CITY OF ALBUQUERQUE

November 25, 2014

**Re: 3440 2nd Street NW
Grading and Drainage Plan
Engineer's Date 11-24-14 (G14D087)**

Based upon the information provided in your submittal received 11-24-14, the above referenced plan is approved for Grading Permit and Building Permit. Please attach a copy of this approved plan to the construction sets prior to sign-off by Hydrology.

DRAWING:	DRAWN BY:	DATE:	SHEET #
201424-GR.DWG	SH-B	10-25-2014	C102

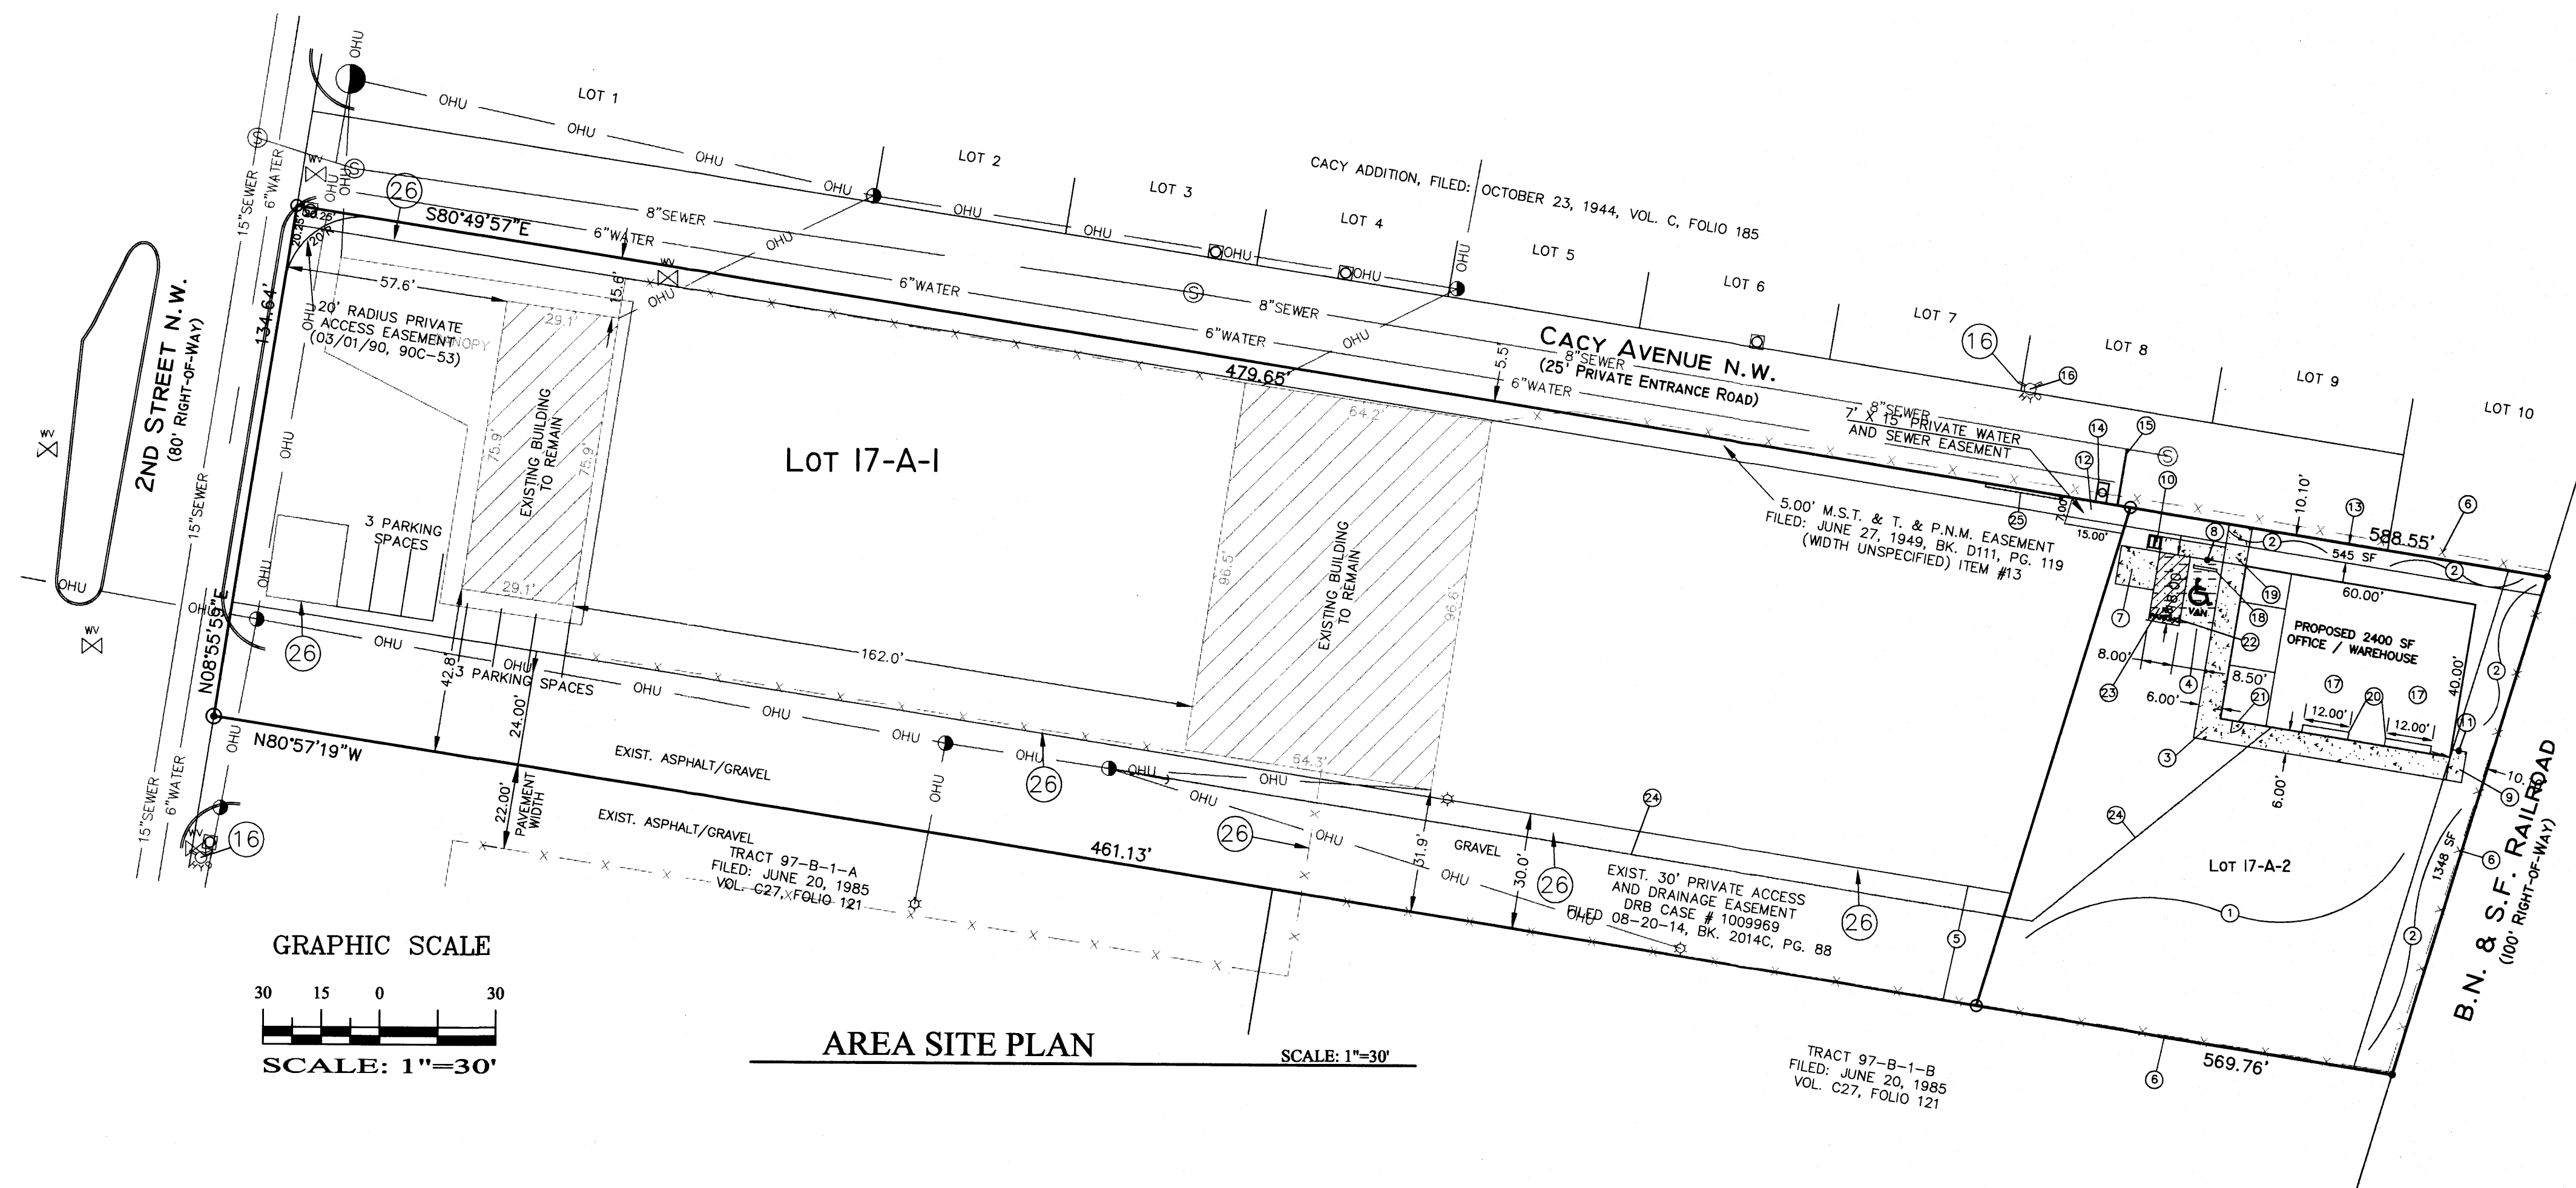
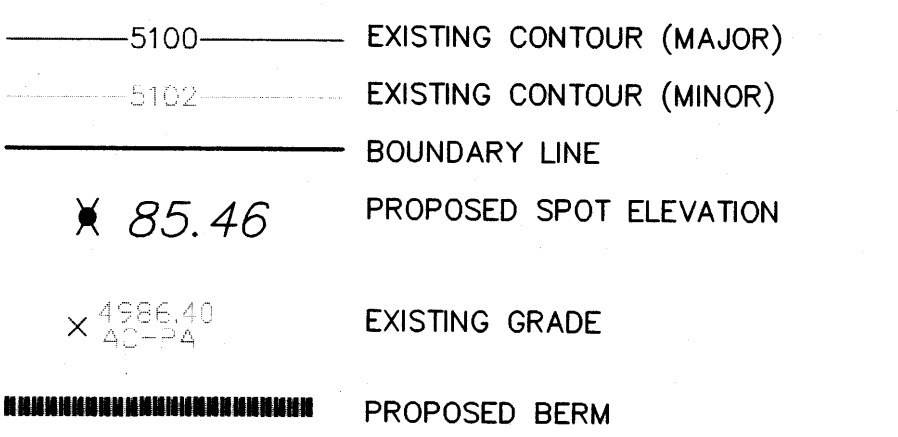
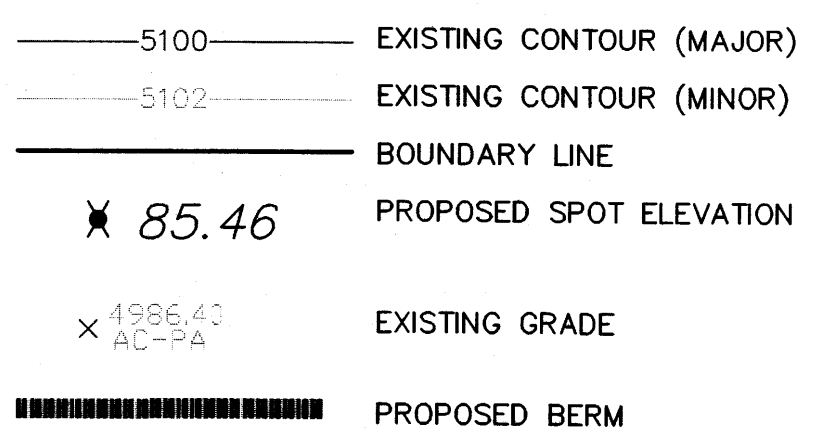
1. A pond is being shown with a top elevation of 4973. The surrounding elevations are as high as 4975. Provide tie-in contours. They should be at less than 3:1 slope in relationship to the pond. Also show how existing grades are being tied into on the full length of the east side of the property. Will there be a steep slope along that edge?

2. The First Flush was not discussed. Per the City Drainage ordinance, the 90th Percentile Storm Event, which is 44 inches, is to be managed. Reduce 0.44 inch by the 0.1 inch for the initial impervious abstraction in Table A-6 of Section 22 of the DPM. Multiply the remaining 0.34 inch by your impervious area. This is the amount of the First Flush necessary for the site. Show that amount on your plans. State that the capacity provided by the proposed pond is greater than what is required for the First Flush.

3. Provide a discussion of the 100 Year Flood Plain.
4. In the AHYMO run for the historical condition, the existing flows should reflect an impervious area that is greater than 40%.
